Application No: BR/13/22/HH
Site Address: 235 Hawthorn Road Bognor Regis PO21 2UW
Description of works: Erection of two storey side extension and single storey rear orangery following the demolition of existing rear conservatory and side extension.

Thank you for your internet representation made on 4th February 2022 which has been recorded as an objection with the comments as follows:

GROUND FLOOR PLAN PROPOSED 1:50

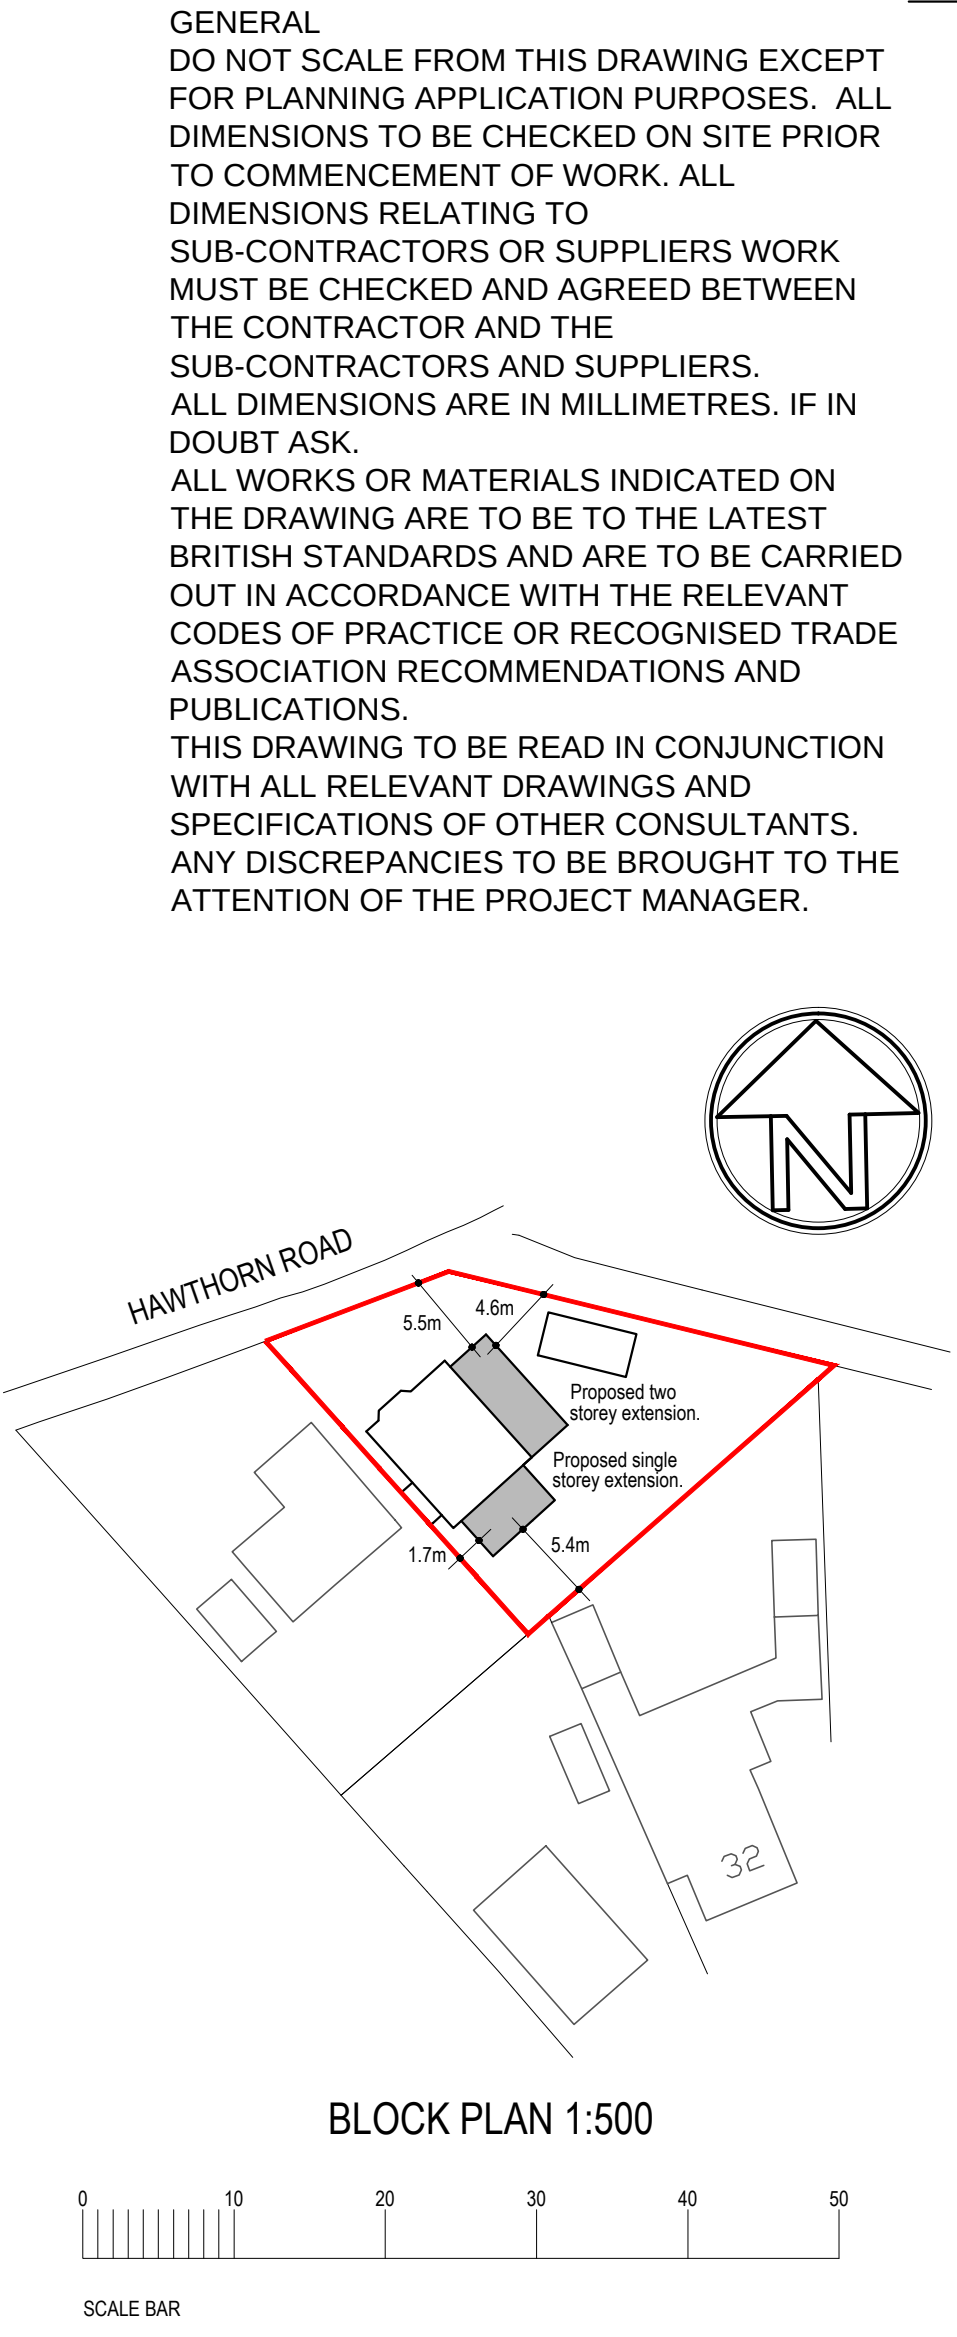
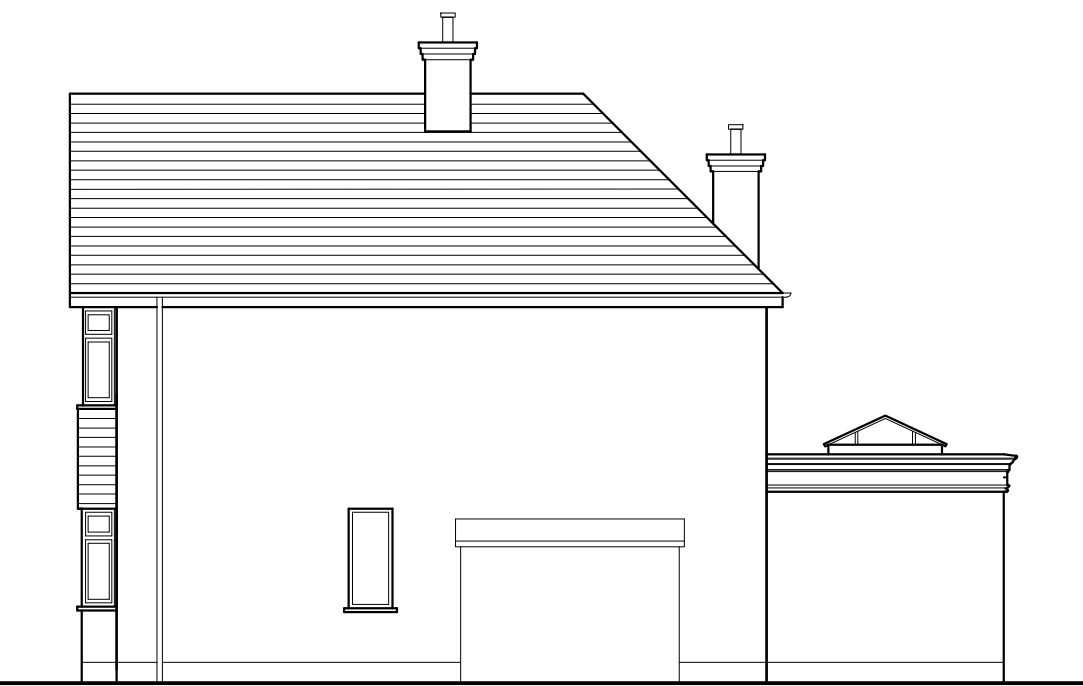
Due to the proposed house being situated on a fairly acute bend on Hawthorn road any windows on the rear of the property at a second story will permit a dual aspect view into multiple homes on crescenta walk.
Whereas we have no effected impact from the proposed development in principle we do take extreme objection to the windows on the second story resulting in zero privacy for the kitchen/ family room and garden of our property and many others on crescenta walk.

Concern is raised to further concrete structures affecting what appears to be a fairly high water table already? I hope consideration can be taken in to the application in omitting the windows to the rear elevation on the second story.
